Ribble Valley Borough Council
Council Offices
Church Walk,
Clitheroe
Lancashire
BB7 2RA

Phone: [REDACTED]
Email: [REDACTED]
Your ref: 3/2025/0147
Our ref: 3/2025/0147/HDC/KW
Date: 16 September 2025

Location: Peel Street Business Estate Peel Street Clitheroe BB7 1RA
Proposal: Proposed demolition of existing buildings and erection of six 2-bed and one three-bed apartment building together with a two storey business centre and associated parking and bin store.
Grid Ref: 374509 441572

Summary

Project No: ALP/23 Dwg 07A **Drawn:** DP

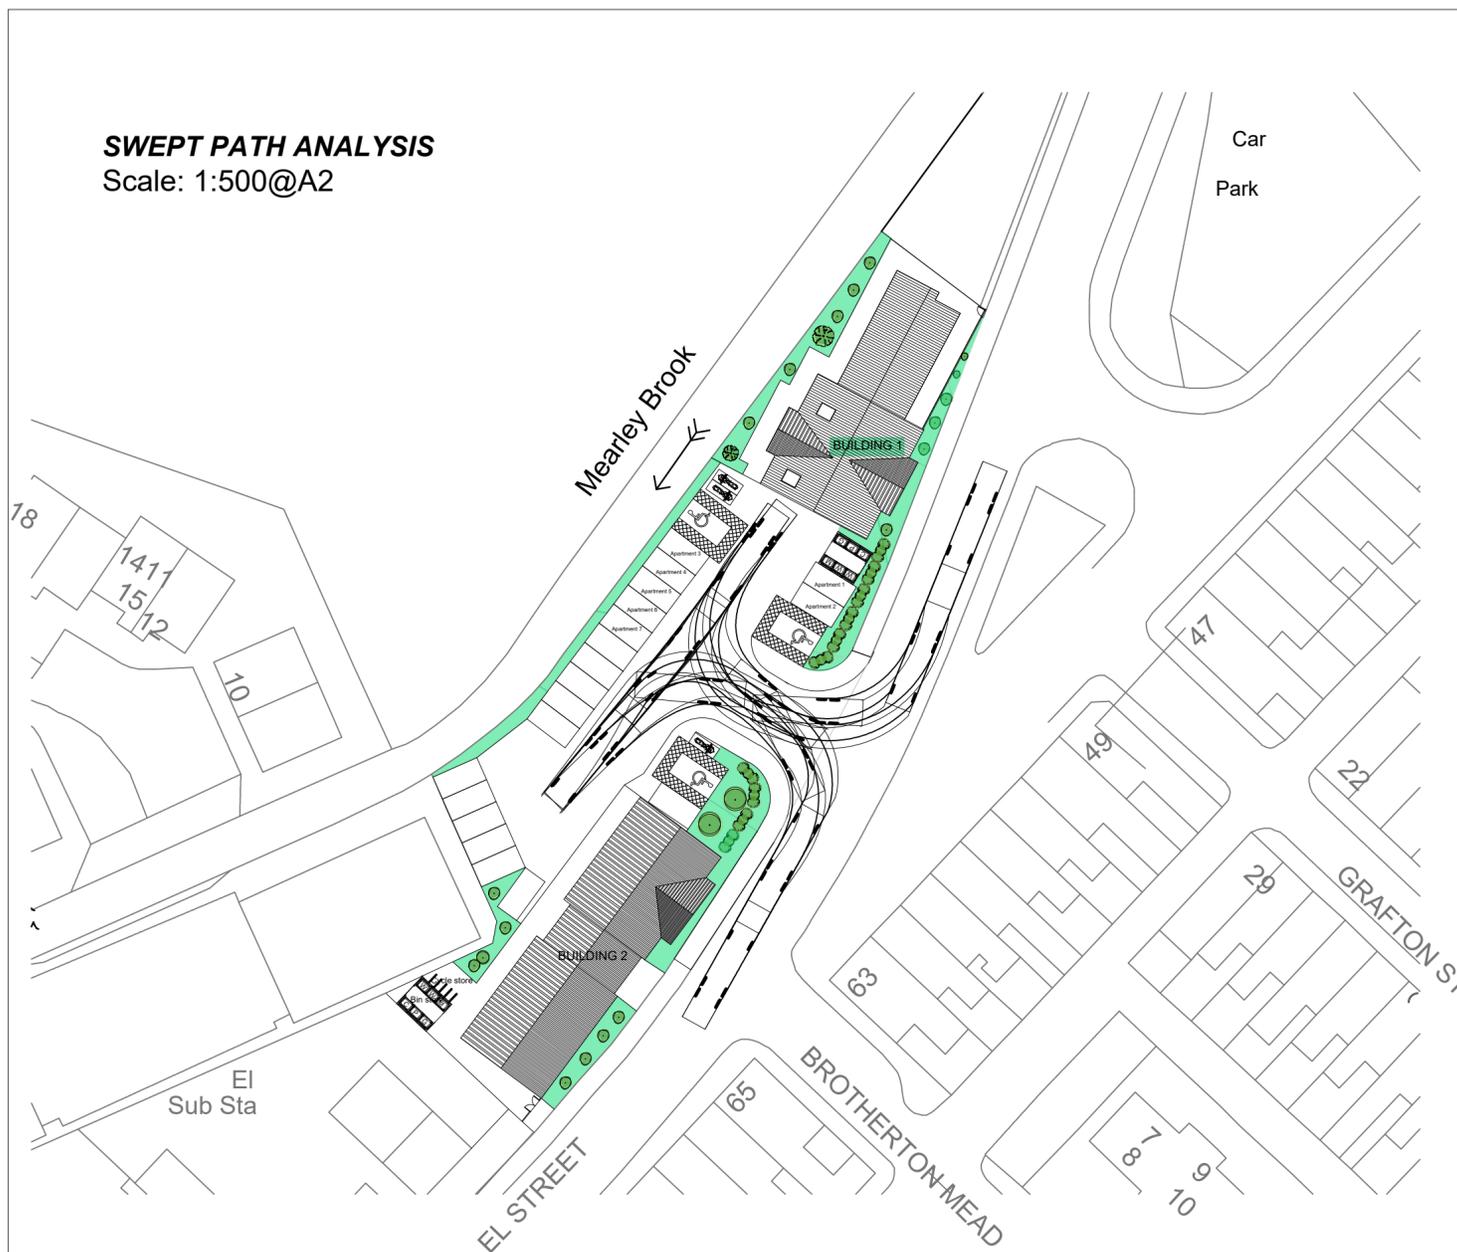
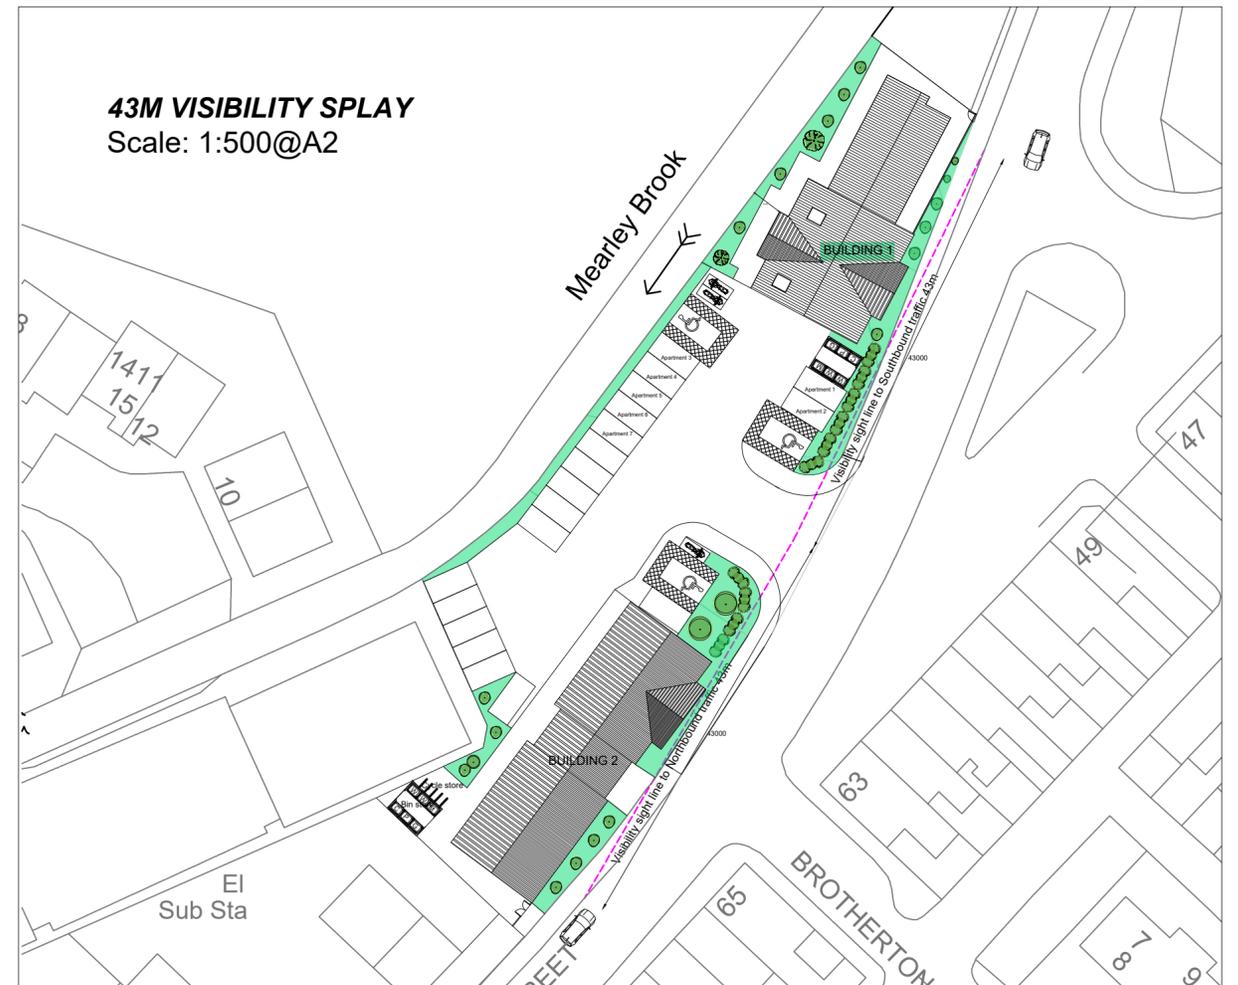
The applicant has also provided an amended swept path analysis drawing ALP/23 Dwg 07A which shows the swept path of a large rigid truck using the access, the applicant has widened the access slightly to enable the vehicle to enter and exit the site without any over running which is acceptable to the LHA. The drawing also included a vehicular visibility splay drawing. This shows that the required vehicular visibility splays of 2.4m x 43m can be achieved in both directions and is therefore acceptable.
